The Drovers Solar Farm

Statement of Common Ground (SoCG) with Environment Agency (Tracked)

Document reference: APP/5.13.2 (Revision 2)

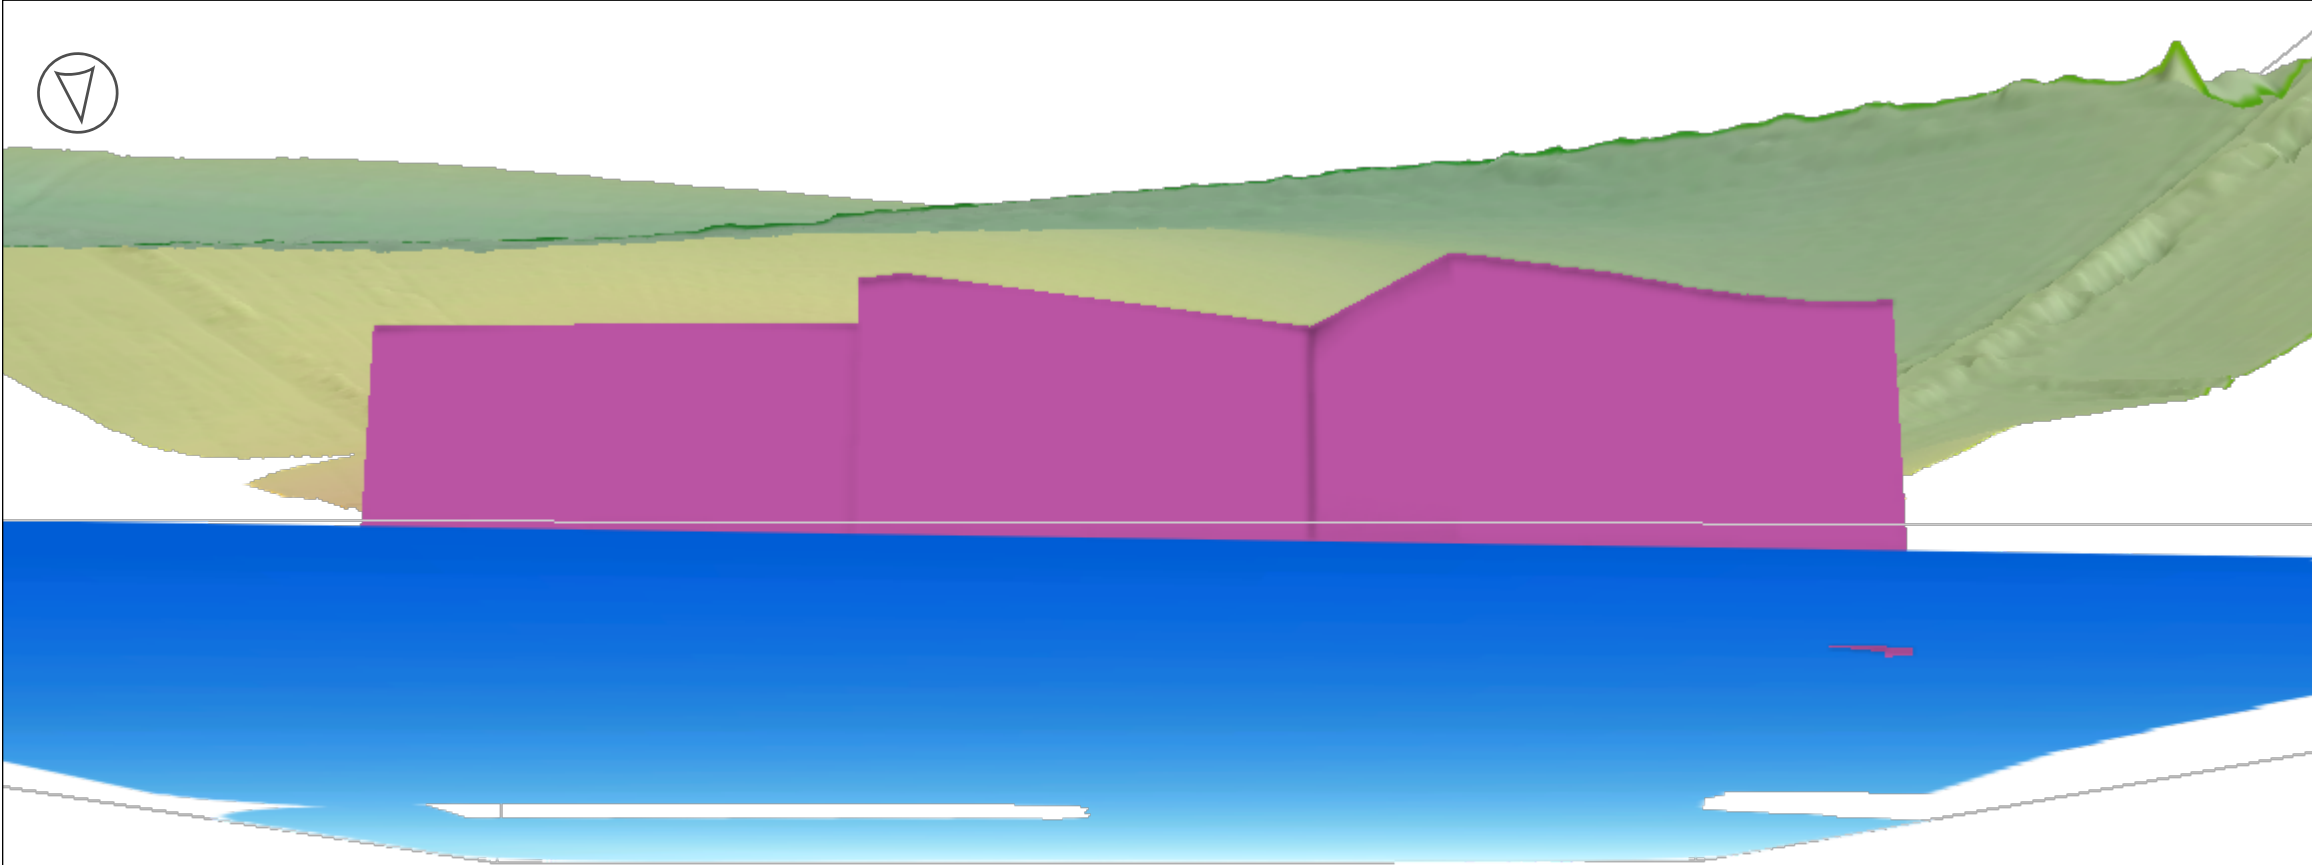
Reference	EA Issue Reference	Topic	Consultee's Position	Applicant's Position	Status
2-1	EA05	Maximum Foundation Extents	Figure 12.13 Work No.2 Piling Locations within CSA for Maximum Groundwater Level [APP-127]	Figures 12.13 to 12.16 of ES Chapter 12: Water Resources [APP/6.2.3APP-061] were used to illustrate the maximum groundwater elevation surface across the Core Study Area and identify where	Medium Agreed

DRAWING TITLE:
ES Figure 12.15 Work No. 4 Piling Locations within
CSA for Maximum Groundwater Level

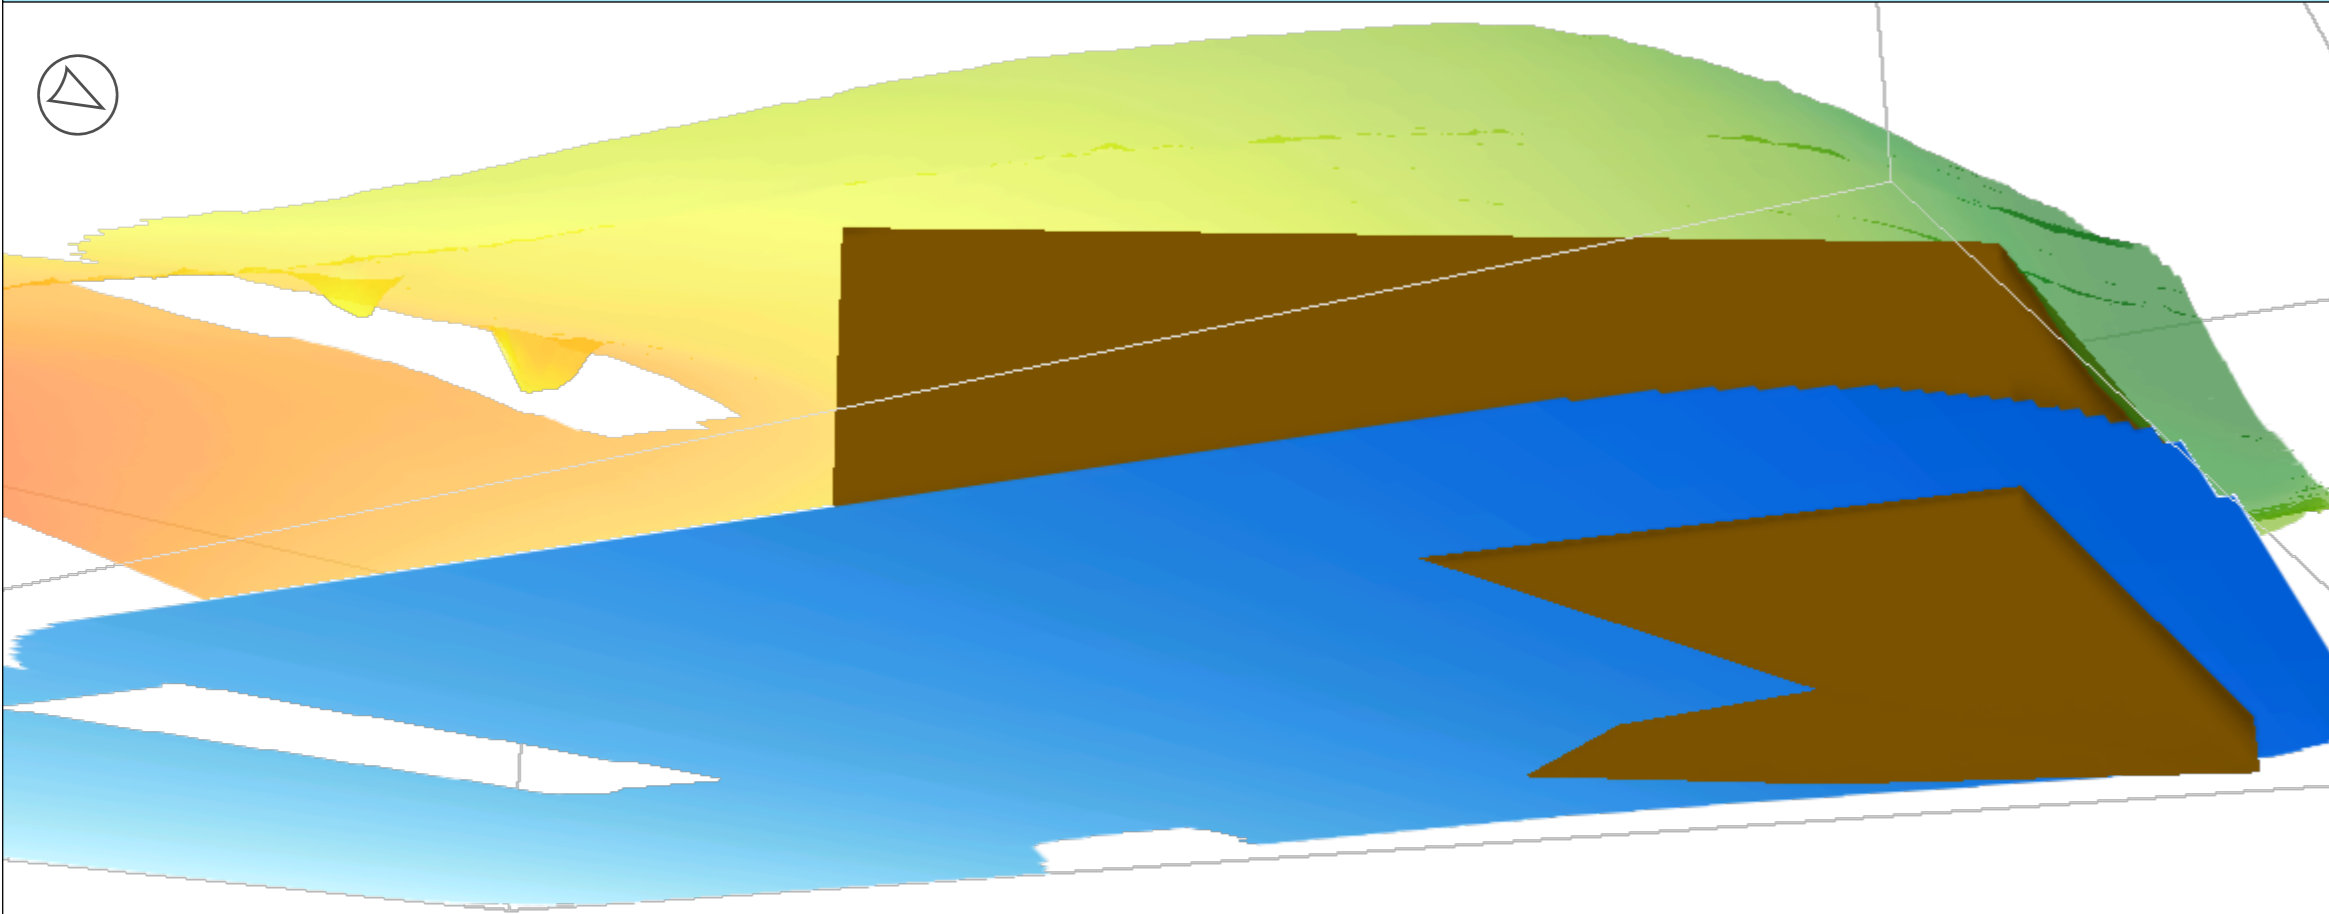
Figure 12.14 Work No. 3 Piling Locations within CSA for Maximum Groundwater Level [APP 128]– Figure 12.15 Work No. 4 Piling Locations within CSA for Maximum Groundwater Level [APP 129]– Figure 12.16 Maximum Foundation Extents for Minimum Groundwater Level [APP 130]– Issue: Figures 12.13 to 12.16 do not clearly show the orientation of each 3D model view, and the elevation of the maximum extent of foundations is not given.– Impact: Difficulty in interpreting figures.– Solution: Revise figures to more clearly define the area represented in the drawings, including view orientation, and the maximum foundations extent should be shaded to show elevation values. The model should be updated to inform detailed foundation design, based on site specific survey and monitoring data.– Additional Comments: Use of inconsistent terminology may also result in confusion. Figures 12.13 to 12.15 are titled to show the anticipated extent of piling in comparison with the maximum groundwater level. In the context of the data presented, the maximum groundwater level in mAOD represents the shallowest extent and therefore worst-case condition for groundwater. For clarity the	proposed foundation depths could theoretically intercept shallow groundwater under worst-case conditions. The figures also demonstrate at a concept level where piling may be required depending on foundation design. The following changes have beenwere made at Deadline 3 to aid the EA's interpretation: • Addition of orientation labels or description • Elevation shading to show mAOD values for the maximum groundwater elevation surface and foundation extent surface • Highlight areas where foundations intersect or exceed groundwater elevation surfaces; and • Figures and text refer to groundwater elevation (mAOD) rather than groundwater level to increase clarity between absolute elevation and depth below ground. The Applicant agrees that the conceptual model present is not the final tool for foundation design, but rather to provide a screening-level assessment of groundwater conditions and to identify areas needing piled or shallow foundations and will be aligned with EA regional groundwater understanding (NEAC model). The Design Principles,

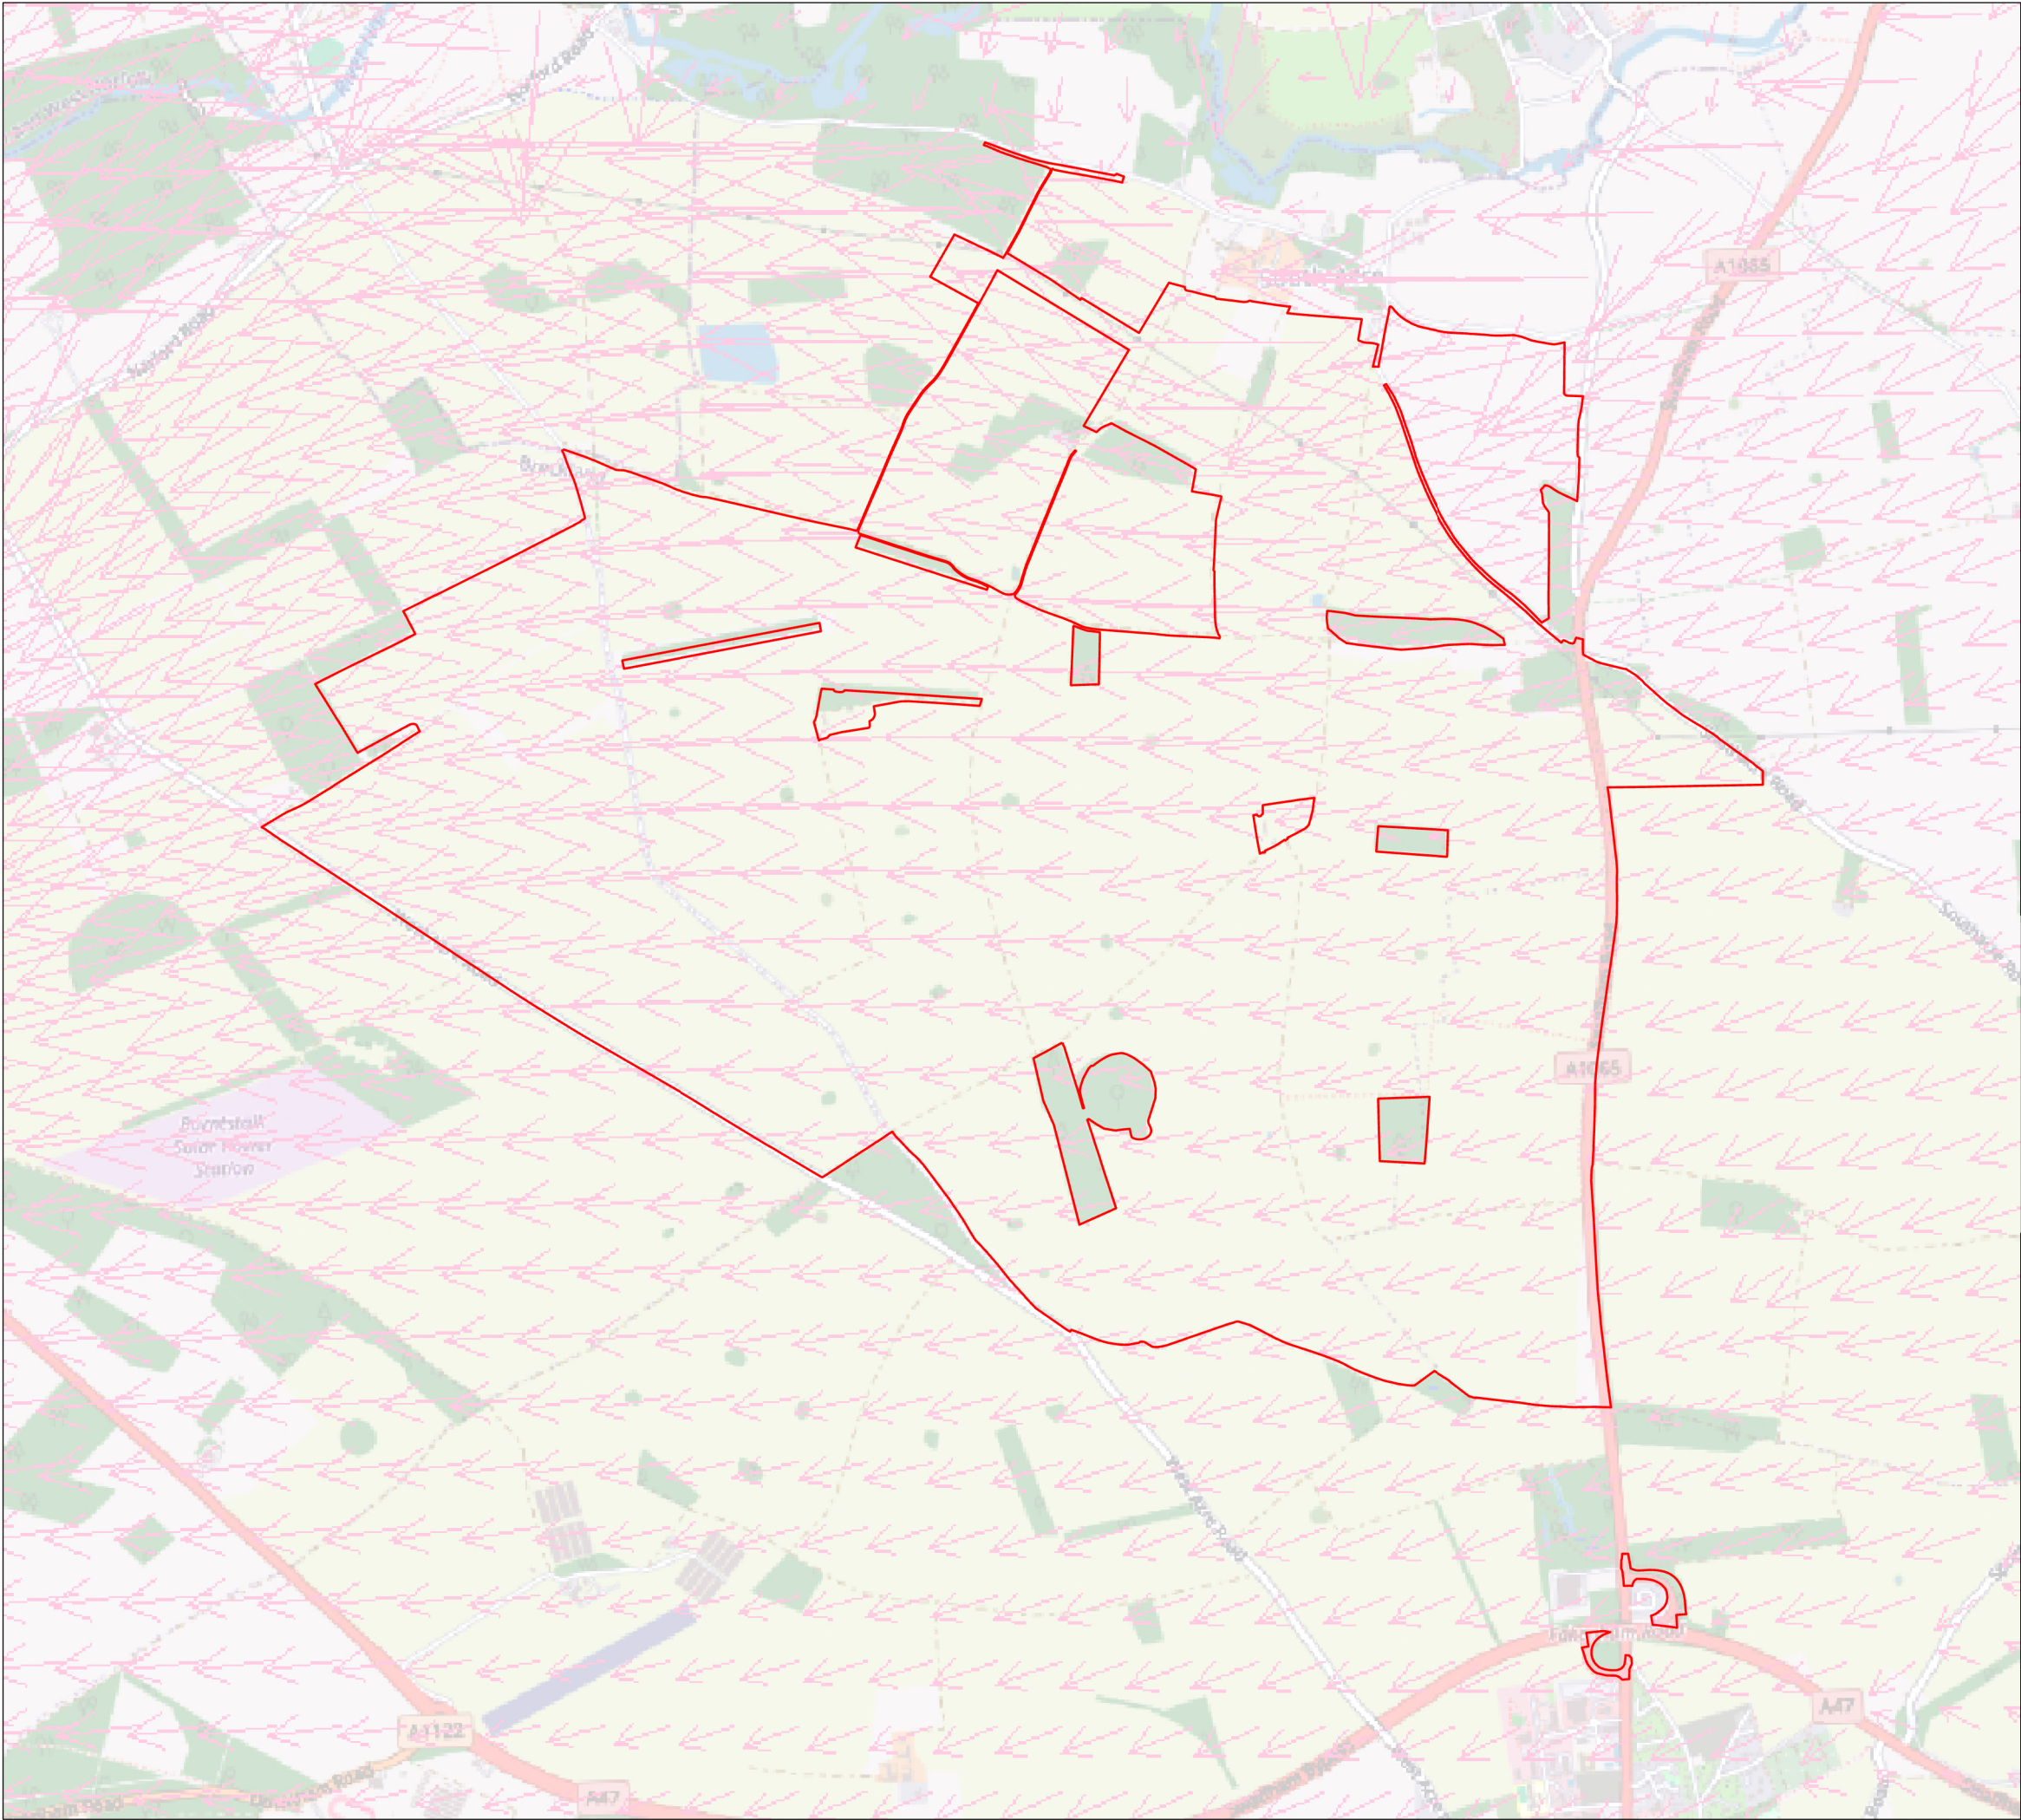
The map shown within Figure 12.10 does appear to be the dry weather scenario output for the Chalk top layer (layer 5 of the model), rather than the wet Scenario referenced in 12.6.44 of 6.2.2 ES Chapter 12 Water Resources (Tracked) [REP3-037].

The new figure 12.10 does show the correct direction, even though it is incorrectly labelled. Considering the Applicant is committed to groundwater monitoring in the 7.6.3 outline Construction Environmental Management Plan (Tracked) [REP3-074], (table 6) this should be sufficient to mitigate risks to groundwater, now that the conceptualisation of groundwater is generally correct.

- To either change the references to Figure 12.10 to the correct scenario (ie.

Wet to Dry) or add the correct figure if available;
